EPA ADVICE ON ENVIRONMENTAL IMPACT STATEMENT

SNOWY HYDRO - KURRI KURRI POWER STATION (SSI-12590060)

The EPA has reviewed the Environmental Impact Statement titled "Hunter Power Project", prepared by Jacobs Group (Australia) Pty Limited, dated 22 April 2021 (EIS).

**Figure 2-2 Proposal Site Layout**

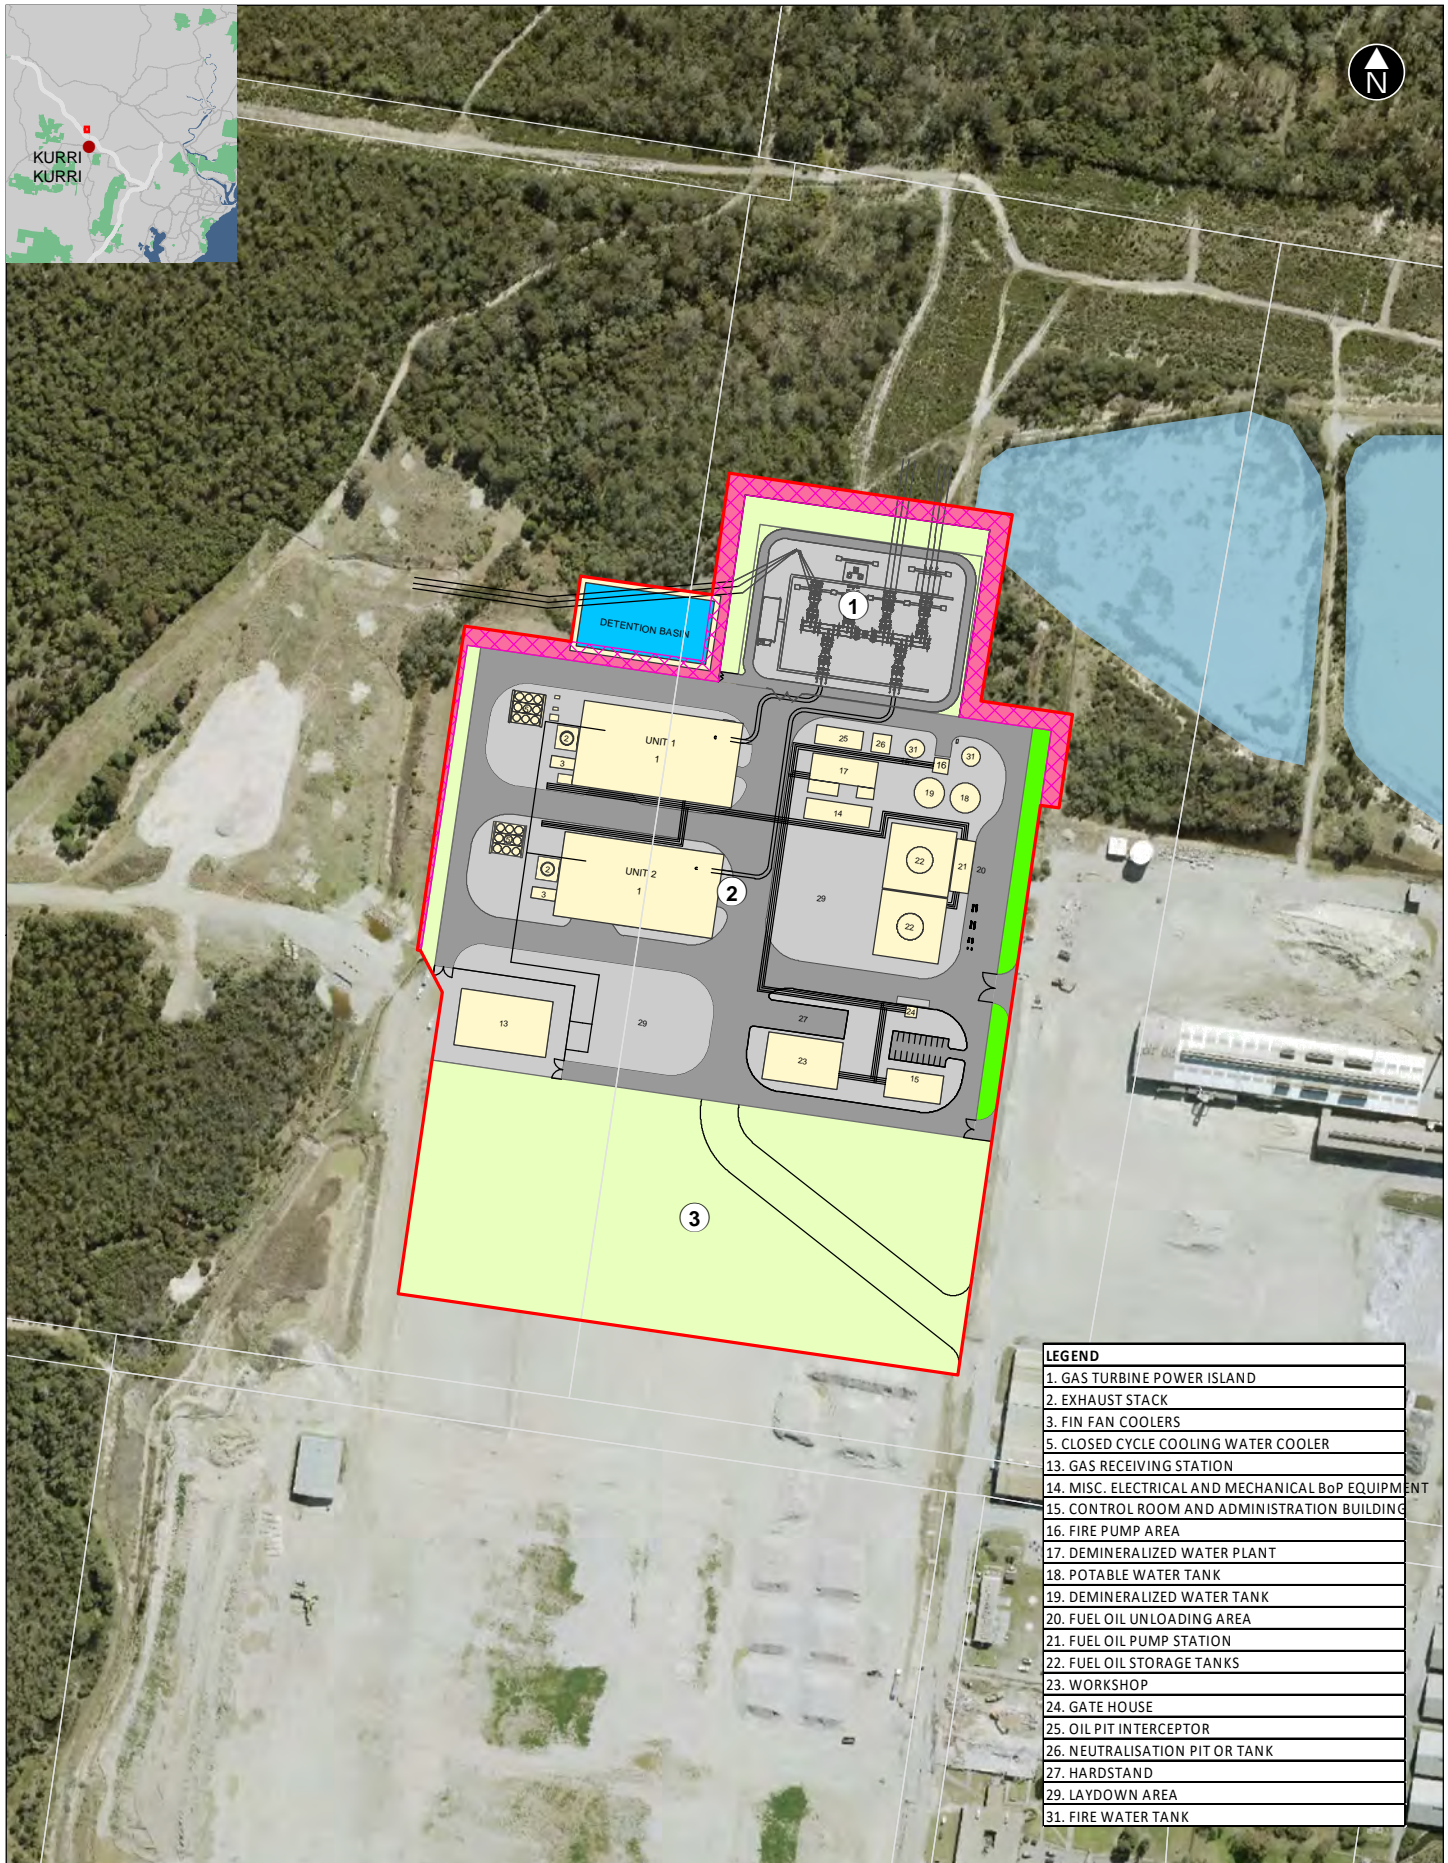
Figure 2.2 indicates 1 exhaust stack per turbine, however, the emission parameters in Table 2.3 are unclear in the derivation of the emission rates and whether they apply per stack or are combined. Additionally, no emission parameters for principal or individual toxics (e.g. formaldehyde, acrolein and PAHs) have been provided.

- *undertake a detailed control technology and emissions performance benchmarking against all relevant international guidance and technologies; and*
- *assess worst-case impacts based on final design. Where final plant design cannot be provided, the proponent must provide all information used to model impacts for all pollutants, including, but not limited to:*
 - *the specific emission factor(s) and/or manufacturer emission parameters,*
 - *all calculations and assumptions used to determine emission rates and concentrations,*
 - *emission parameters provided at reference conditions and per stack.*
